**Sent:** 10 July 2012 16:03  
**To:** Planning  
**Subject:** Planning application N6/2012/1094/FP - 47- 49 Burrowfield

**Response to Planning application from Hertfordshire County Council (T and CP GDP Order 1995)**

**District ref:** N6/2012/1094/FP  
**HCC ref:** WH/252/2012 (Amended)  
**HCC received:** 10/07/2012  
**Area manager:** James Dale  
**Case officer:** Lindsey Lucas

**Proposal**  
Retention of new office building and security fencing and gates

Org.No: AT372-02

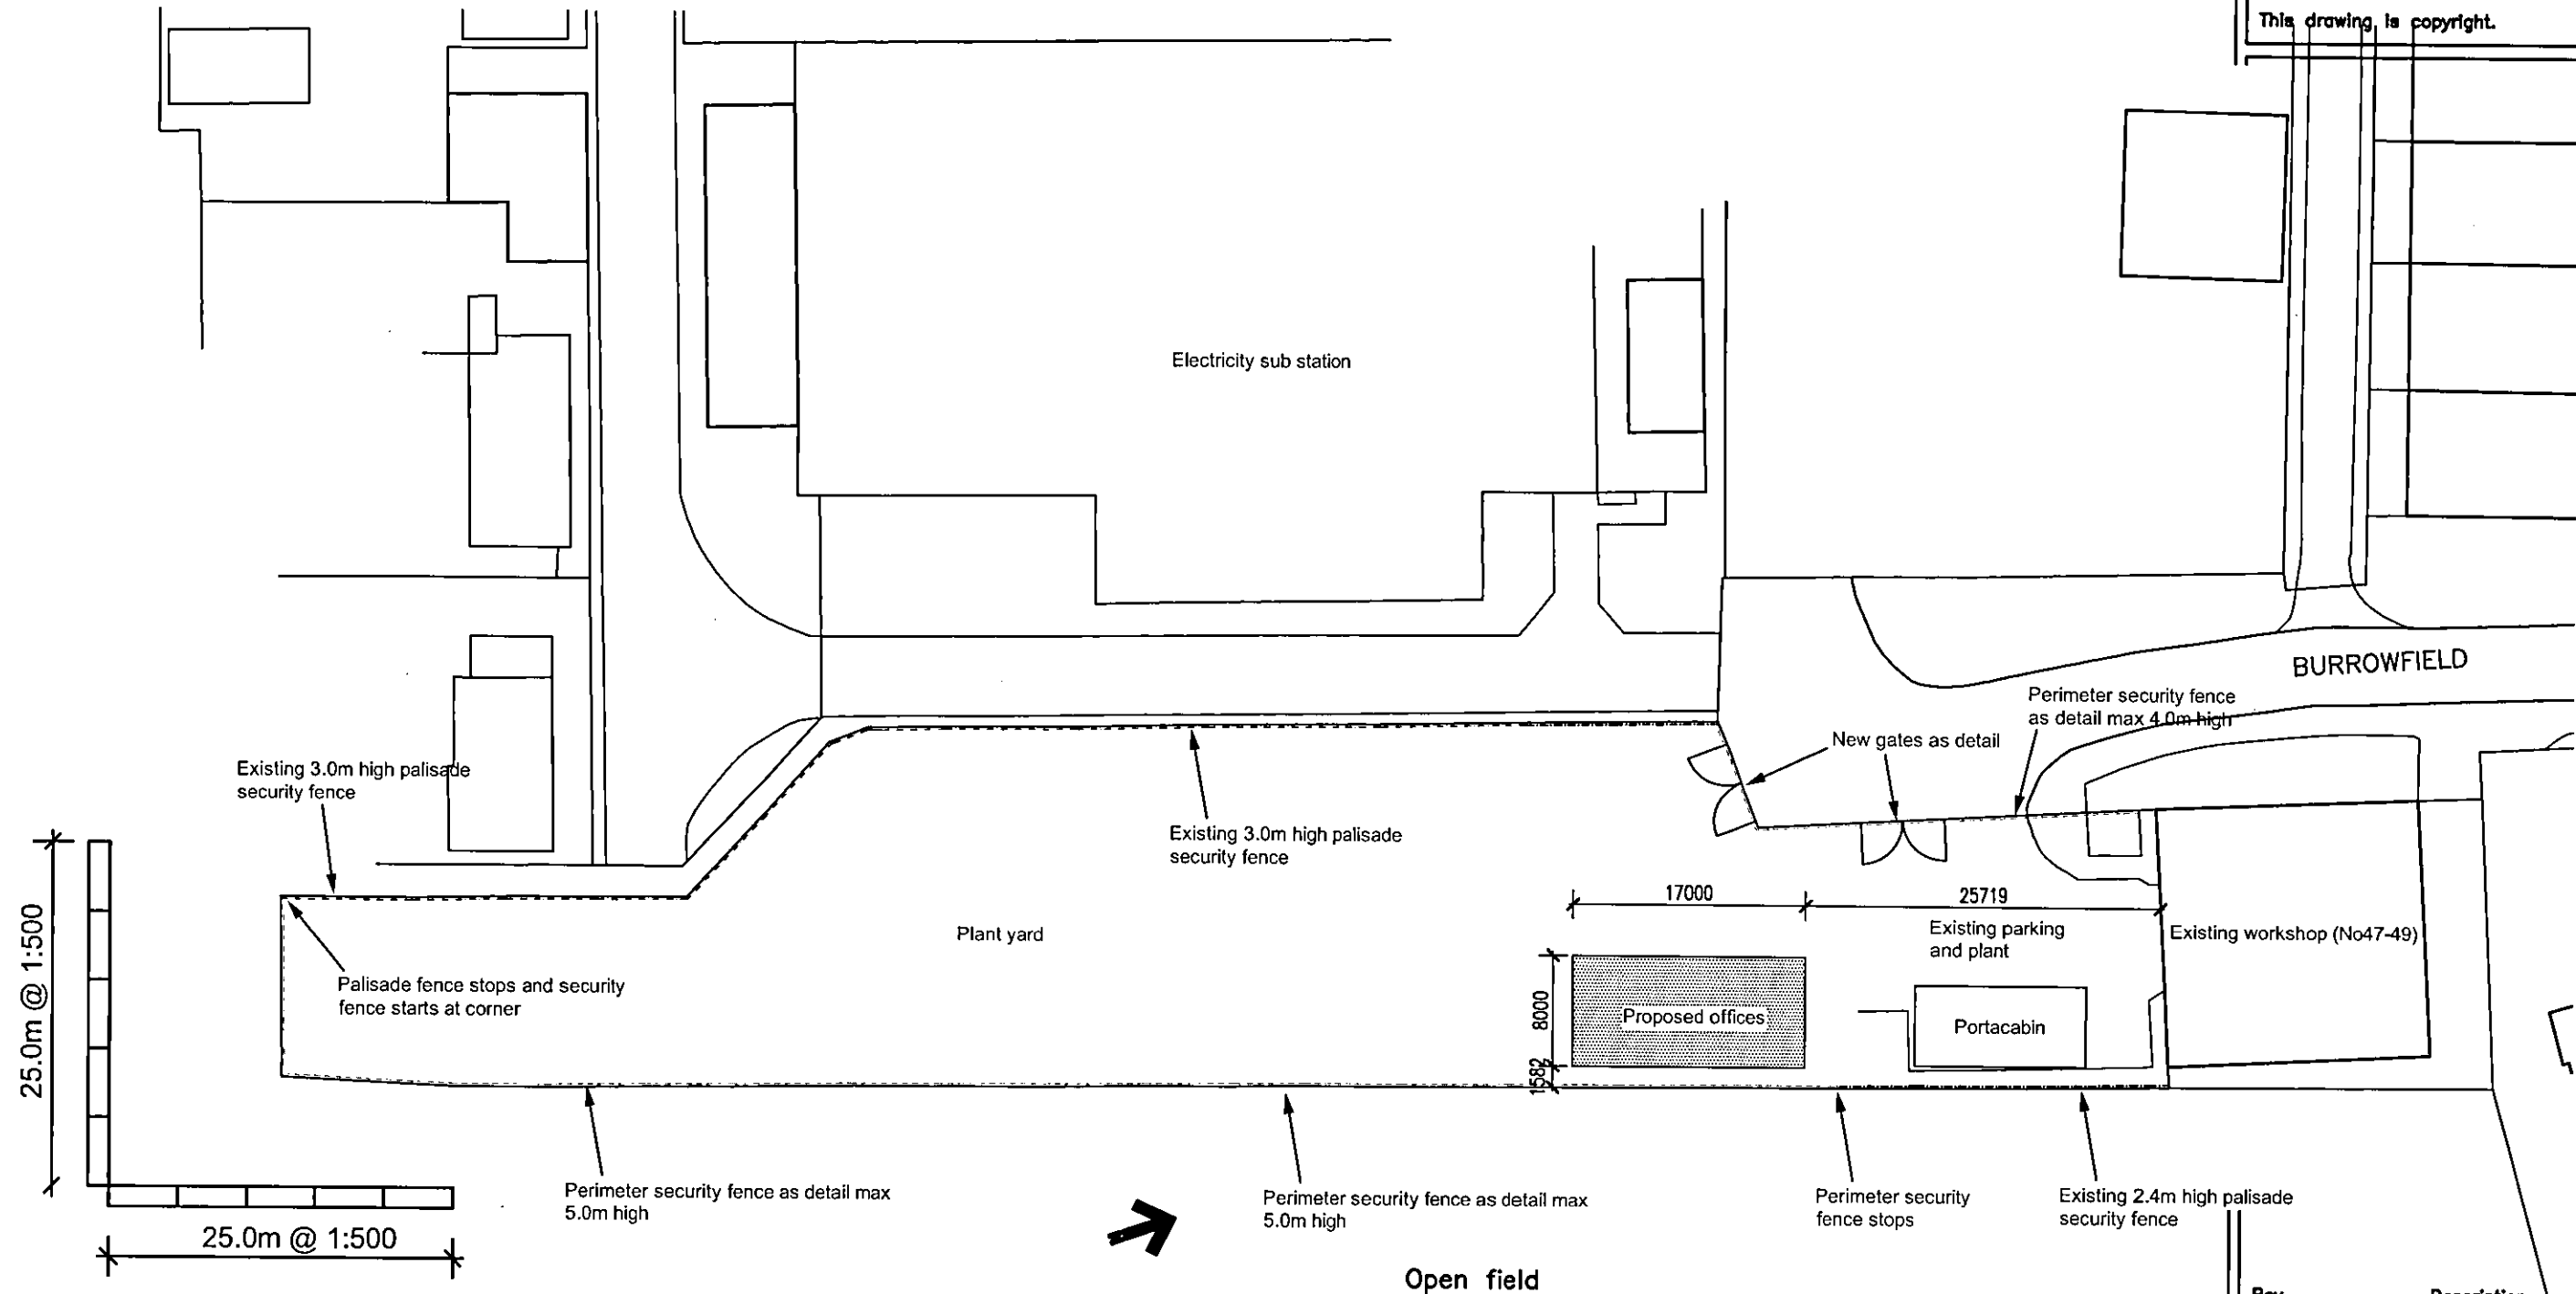
The proposal is for the retention of new office building and security fencing and gates. Burrowfield is a local access road and serves a number of industrial properties. Although the Design and Access statement states that there is space on site available for parking, no parking layout plan was originally submitted as part of the application. From my site visit I also noticed that cars park perpendicular to the building marked as "existing workshop" on the Site Plan number AT372-02, however there is no dropped kerb to serve these parking spaces and if they are to be included as part of the parking provision for the site then a dropped kerb should be provided.

A revised site plan AT372-02A has now been submitted and this shows parking for 8 mixer trucks, 8 staff cars and 2 visitor spaces. These are all contained within the site and sufficient manoeuvring space is retained to enable vehicles to enter and leave the site in a forward gear. Providing the site is laid out as

shown on this revised plan, the proposals will not impact on the surrounding highway network. The proposal will not result in a significant increase in vehicle trips to the site.

- 1. The area set aside for parking as shown on drawing number AT372-02A shall be laid out and surfaced before the development hereby permitted is first occupied and shall be retained permanently there after for the parking of staff and delivery vehicles operating from the site and shall not be used for any other purpose.
